Our Case Number: ACP-323849-25

Re: The proposed development is for a mixed use development that seeks the regeneration and adaptive reuse of a strategic brownfield site, as part of the Limerick City and County Council 'World Class Waterfront revitalisation and transformation project' 'Cleeves Riverside Quarter' in the townland of Farranshone More in Limerick City.

Formal Observation / Objection

Re: Proposed Development — Cleeves Riverside Quarter / Cleeves Riverside Campus

1 Stonetown Terrace Ground Floor Plan
1 : 200

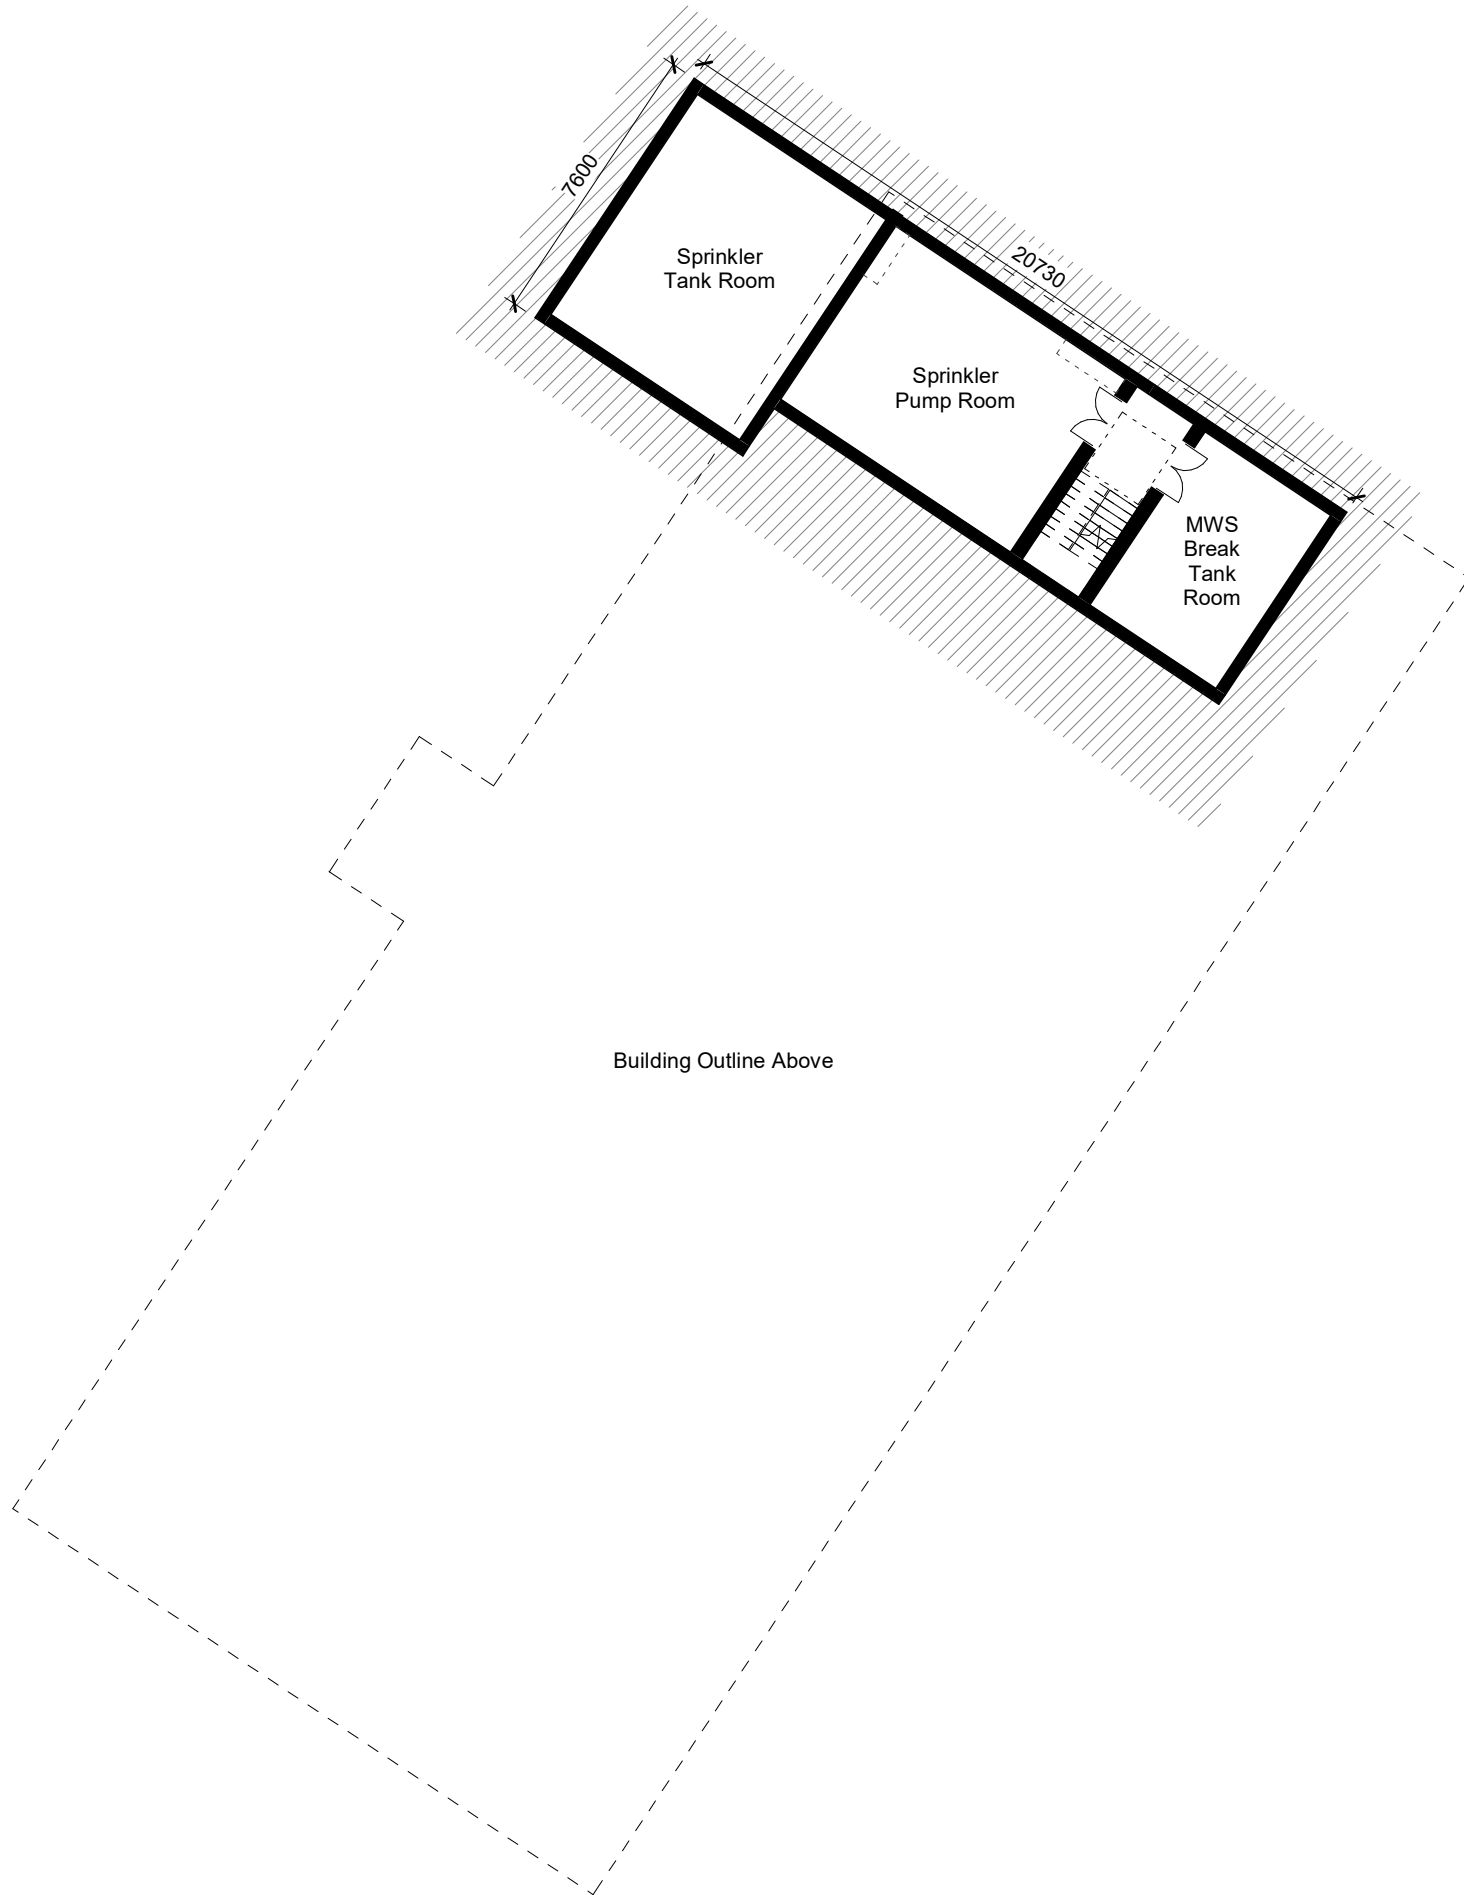
I finally received an incomplete reply to my correspondence on the 25th of November 2025 which informed me that a 21 meter, five story apartment building would be built 12.2 meters from the rear of my house. This reply only came when the planning application had been lodged with An Coimisiún Pleanála. This clearly shows zero prior consultation as the views and concerns of myself and local residents were neither invited or considered. We were denied the necessary information to properly formulate and express our concerns .

2. The Stonetown Terrace development is clearly inappropriate for its location. The five-storey development is towering over the two-storey family home residential areas of Clanmaurice Avenue, Clanmaurice Gardens and Strandville Gardens. It is towering over the largely two storey family development at Landsdowne Hall. The development is visually insensitive and obtrusive.

This correspondence was created in December 2025. It is quite clear from observation of the site that the five-storey block development will have a major impact on daylight. Standing at the rear of my family home it is patently obvious that a 21-metre monolithic block within 10 metres of my house clearly blocks sunlight. At the rear of our premises is a sunroom which gets the morning sun and clearly with this development in place the sun light would be effectively blocked.

- Limit buildings within 30m of Clanmaurice Ave. to 3 storeys
- Step back higher elements; vary rooflines
- Stronger integration of industrial heritage and material diversity
